**KIRKLEES METROPOLITAN COUNCIL  
INVESTMENT & REGENERATION SERVICE**

**DELEGATED DECISION TO DETERMINE PLANNING APPLICATIONS**

Reference No:	<b>2024/62/92431/W</b>
Site Address:	10, Netherley Drive, Marsden, Huddersfield, HD7 6HL
Description:	Erection of car port to side and canopy to front porch, formation of sloping front driveway and alterations to windows and doors
Recommending Officer:	Joshua Merriman

## HOUSEHOLDER DELEGATED REPORT

Date 08.08.24	Project number J24-068	Scale (@ A3) 1 : 100
Drawn by bl	DRAWING NUMBER P14	REV 1

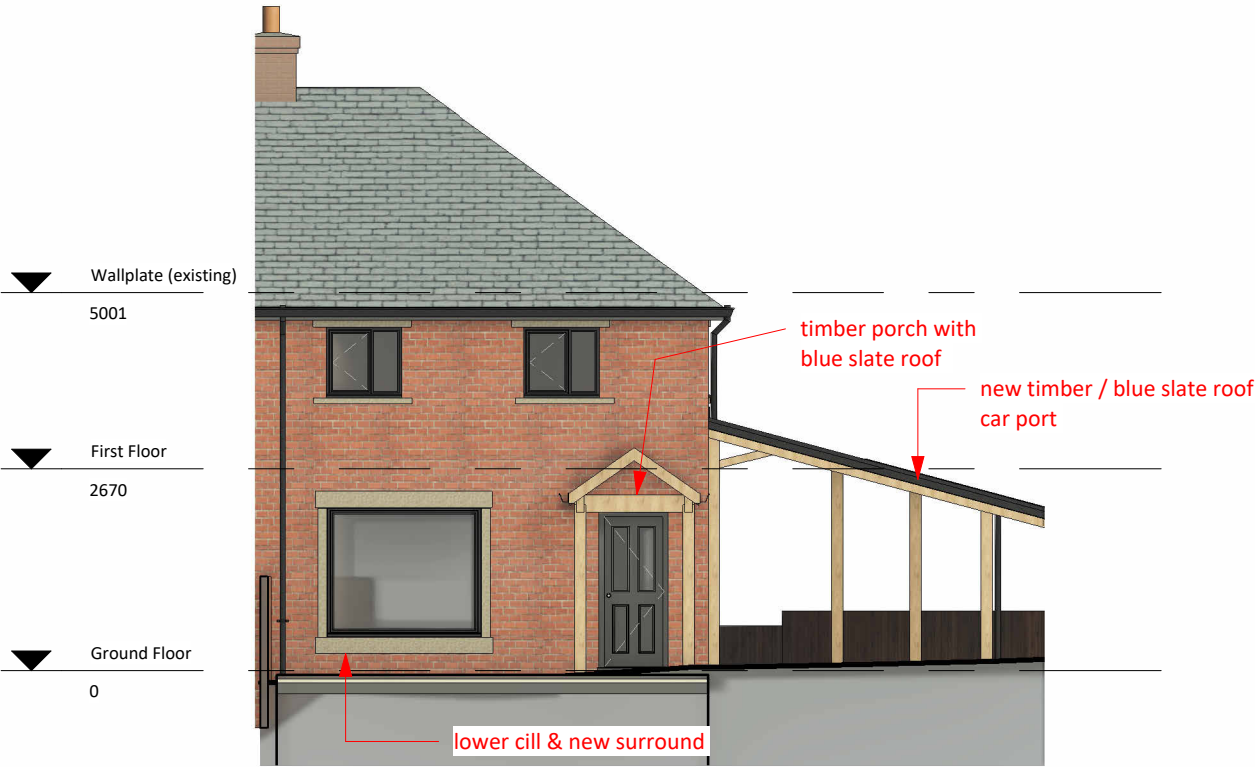
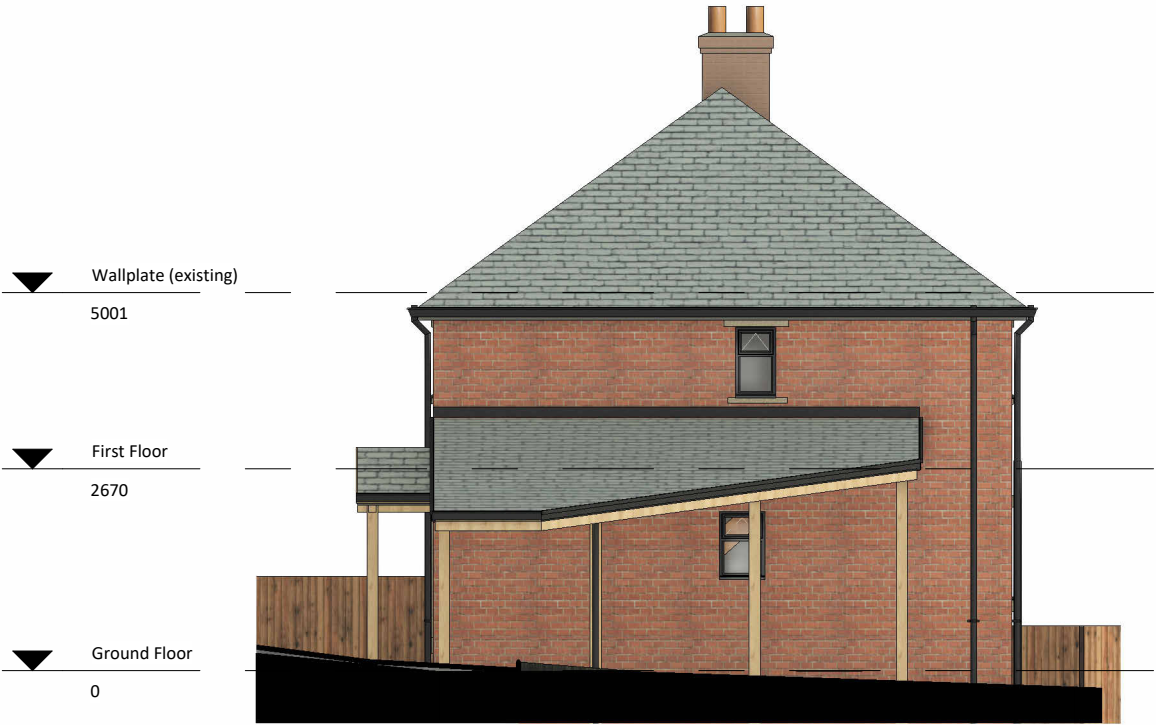
Negotiations/Amendments during course of application	Yes	The use of dark grey roof sheeting on the car port has been amended to a blue slate roof to match the original building. Representations received raised the possibility of the development being sited 50cm from the site boundary. The amended plans demonstrate this distance would be achieved.
Parish/Town Council comments sought	No	
Planning History	No	
Consultations required	Yes	KC Highways – Requested a swept path from the applicant to determine if a wider dropped curb is necessary and request a parking plan for two spaces. They recommended there adequate space for a bin collection point on private land is achieved and advised the applicant be made aware that a section 184 agreement is needed for the dropped crossing.

Pursuant to article 35 (2) of the Town and Country Planning (Development Management Procedure) Order 2015 and guidance in the National Planning Policy Framework, the Local Authority have, where possible, made a pre-application advice service available, complied with the Kirklees Development Management Charter 2015 and otherwise actively engaged with the applicant in dealing with the application. It was considered necessary to seek an amendment for the roof material used on the proposed car port, changing this from grey roof sheeting to a blue slate roof that matches that of the existing dwelling.

Date 08.08.24	Project number J24-068	Scale (@ A3) 1 : 200
Drawn by bl	DRAWING NUMBER P10	REV 3

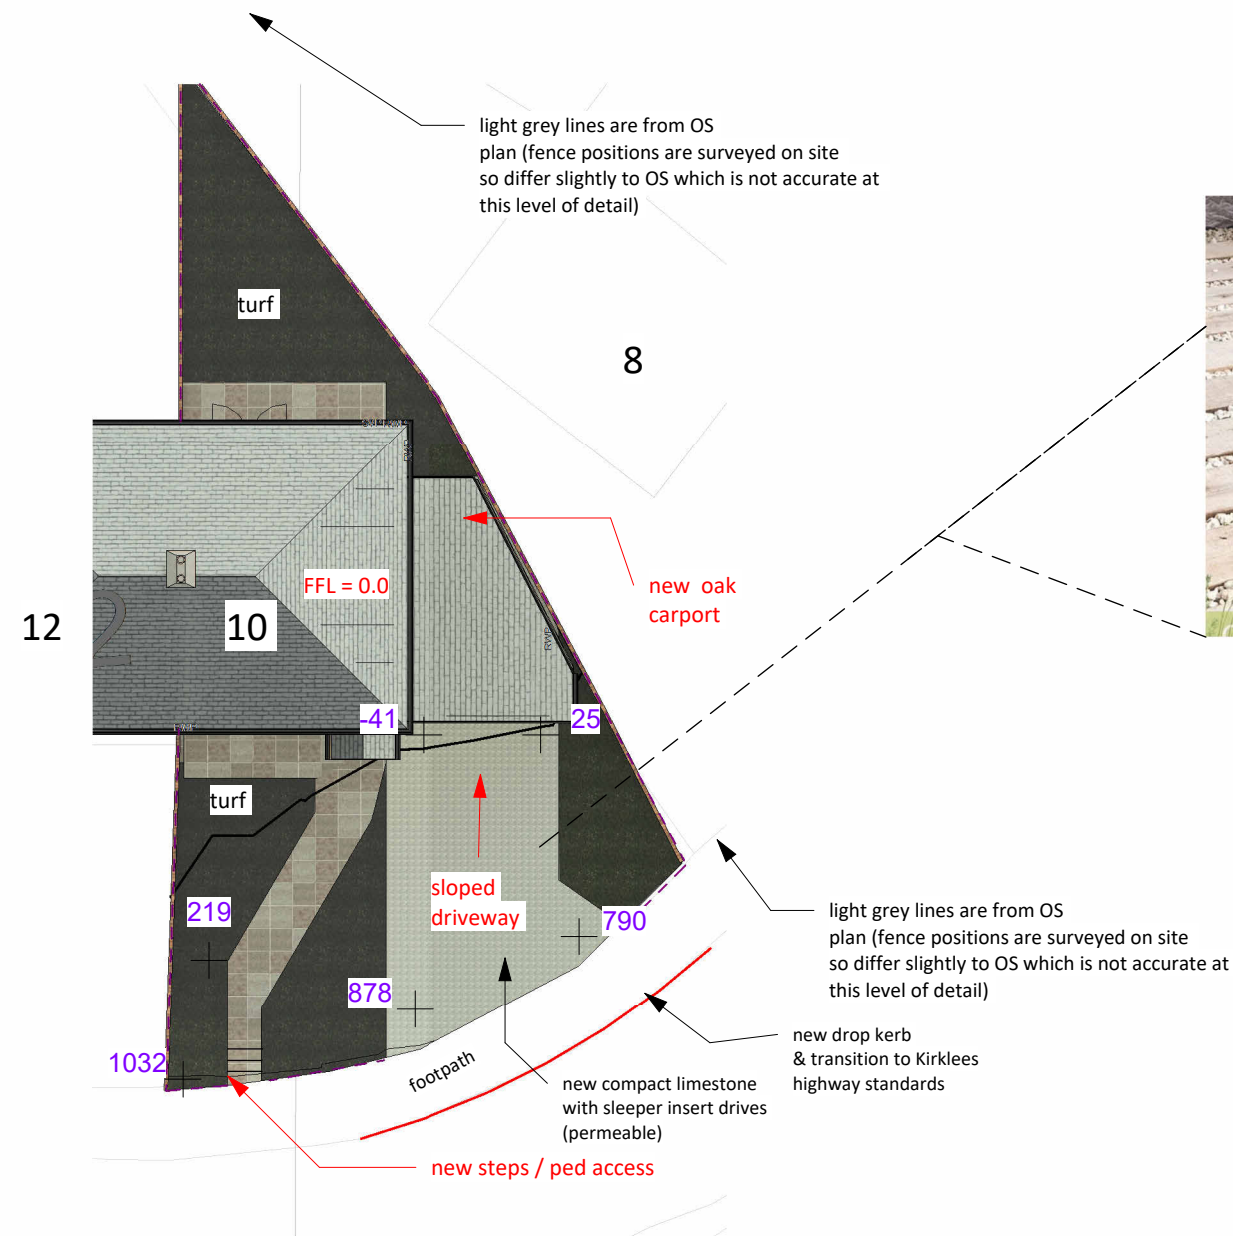
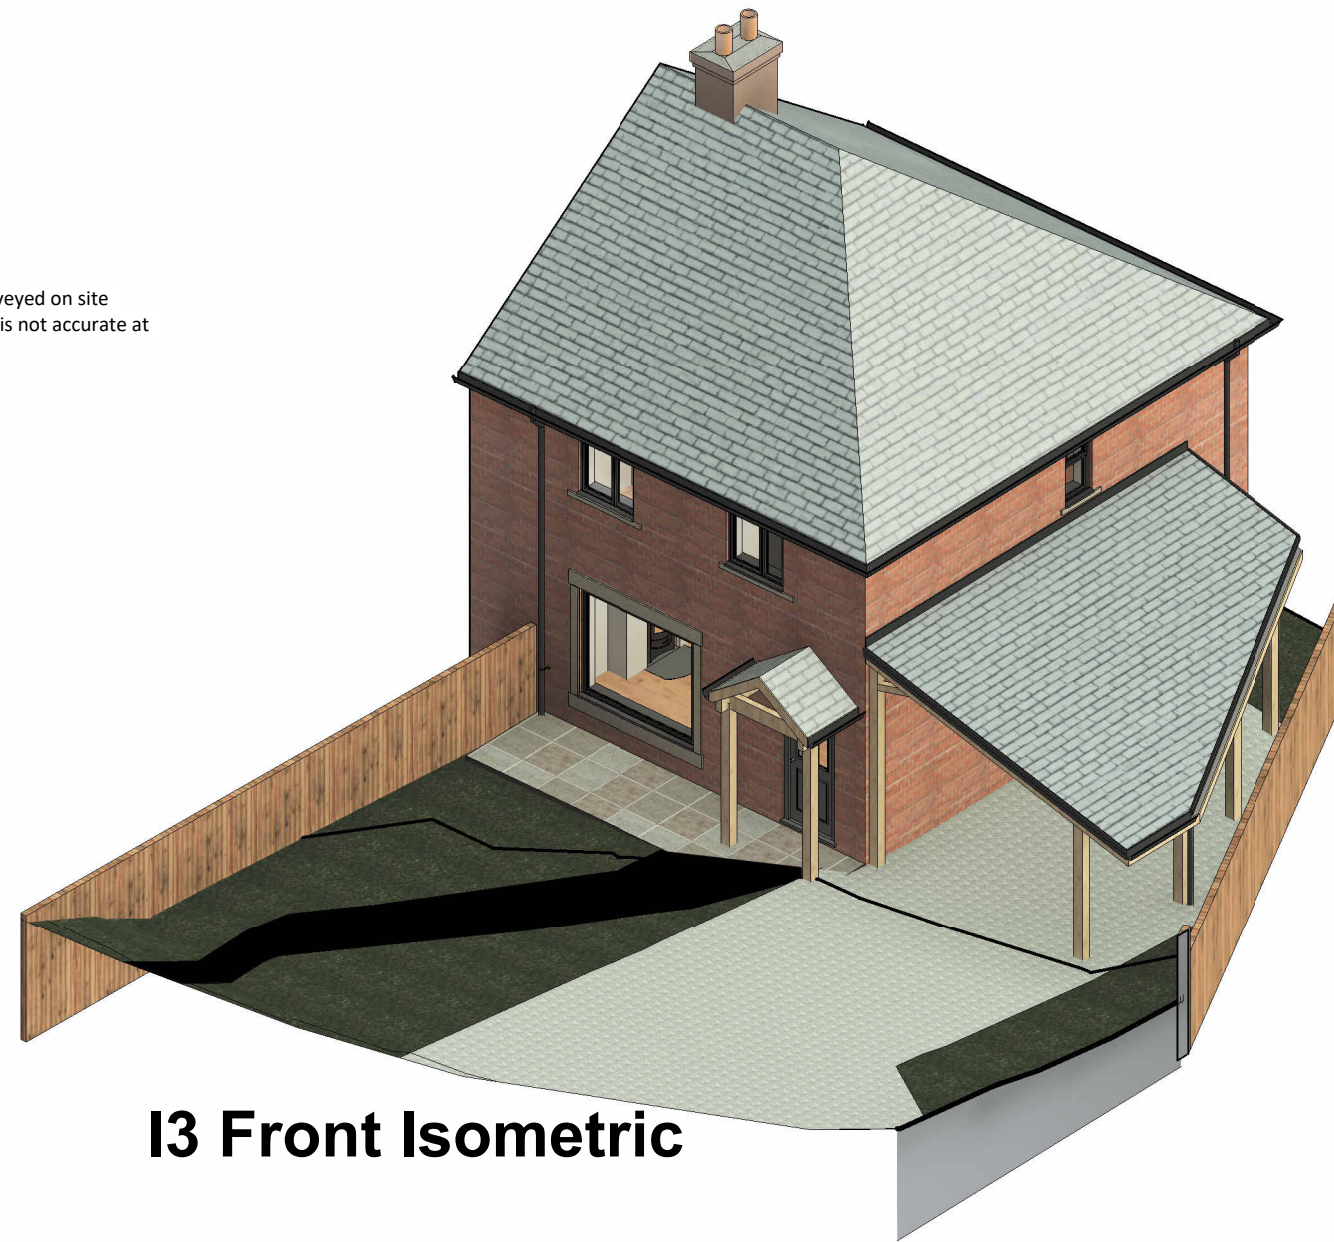
Summary of Representation	Officer response	Addressed ✓ / X / N/A
<ul style="list-style-type: none"> <li>Consider the plans to look great.</li> <li>Extra debris / run off should fall from Car port roof within curtilage of the site by a gap of 50cm being provided between the side of the extension and the boundary.</li> </ul>	Amended plans were submitted showing a 0.5m distance being provided between the boundary of the site and the side / gutter of the proposed development.	✓

Date 08.08.24	Project number J24-068	Scale (@ A3) 1 : 100
Drawn by Author	DRAWING NUMBER P11	REV 3

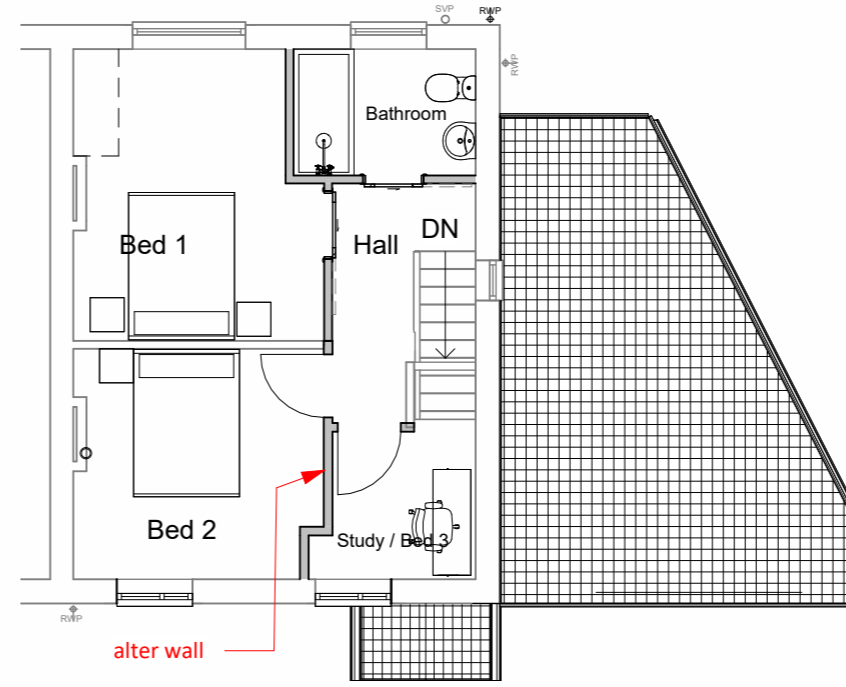
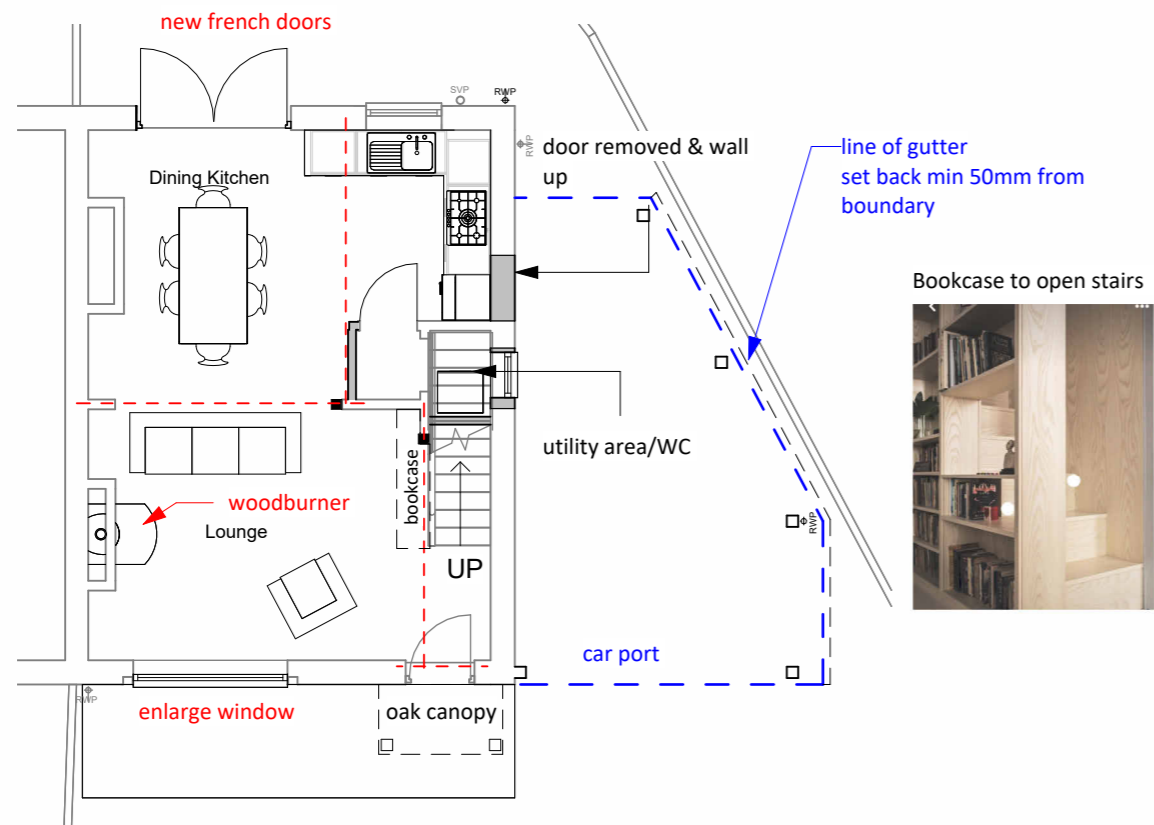
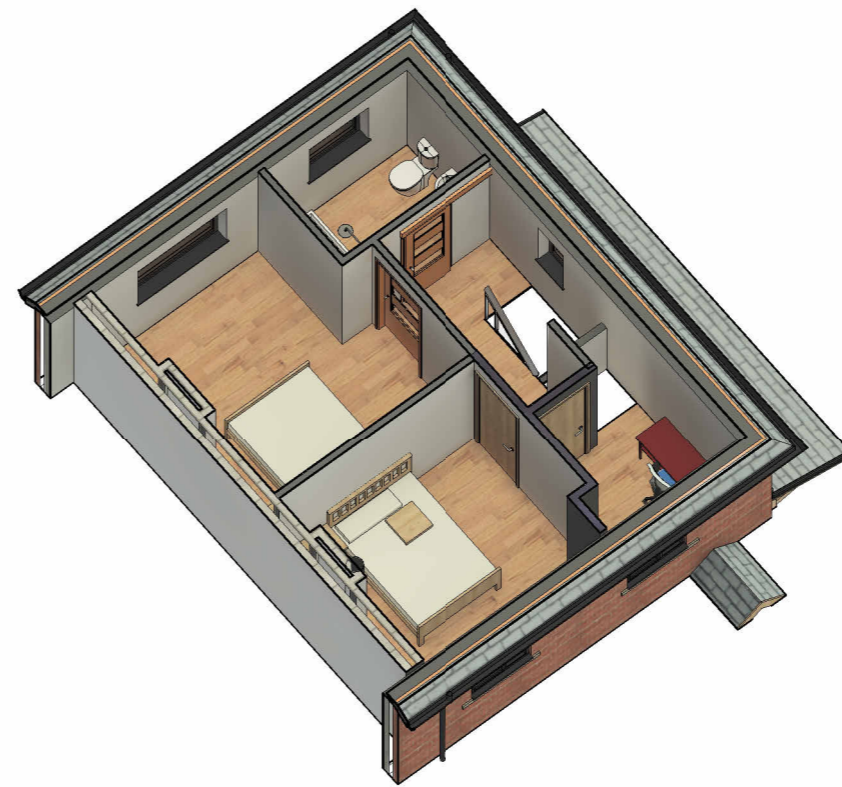
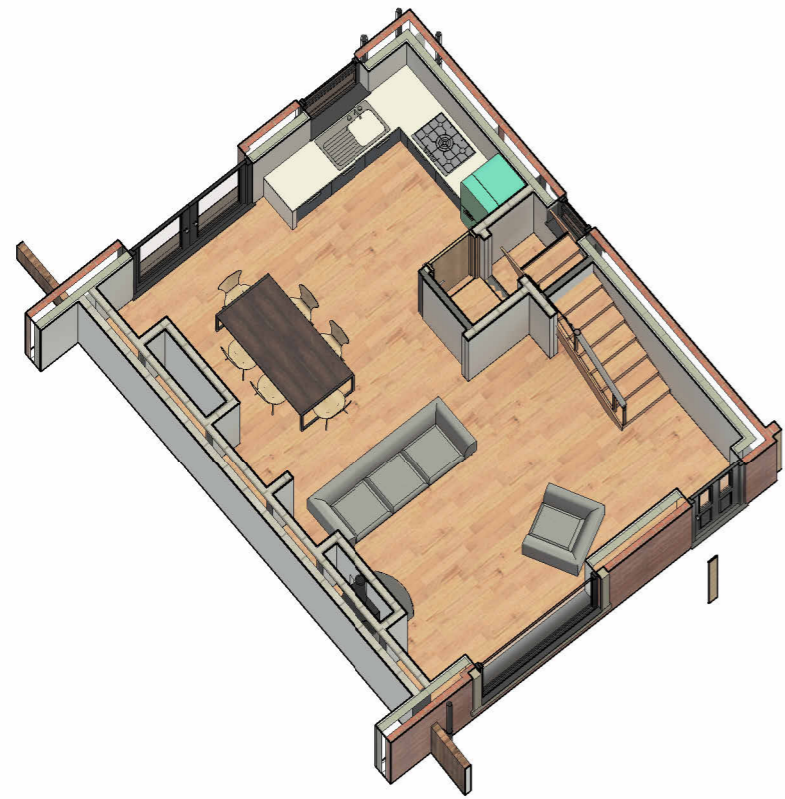
The proposed car port has a minimum projection from the side of the property of 1.82m and a maximum projection of 4.45m, with a length of 6.49m, maximum height of 3.34m and an eaves height of 2.92m.
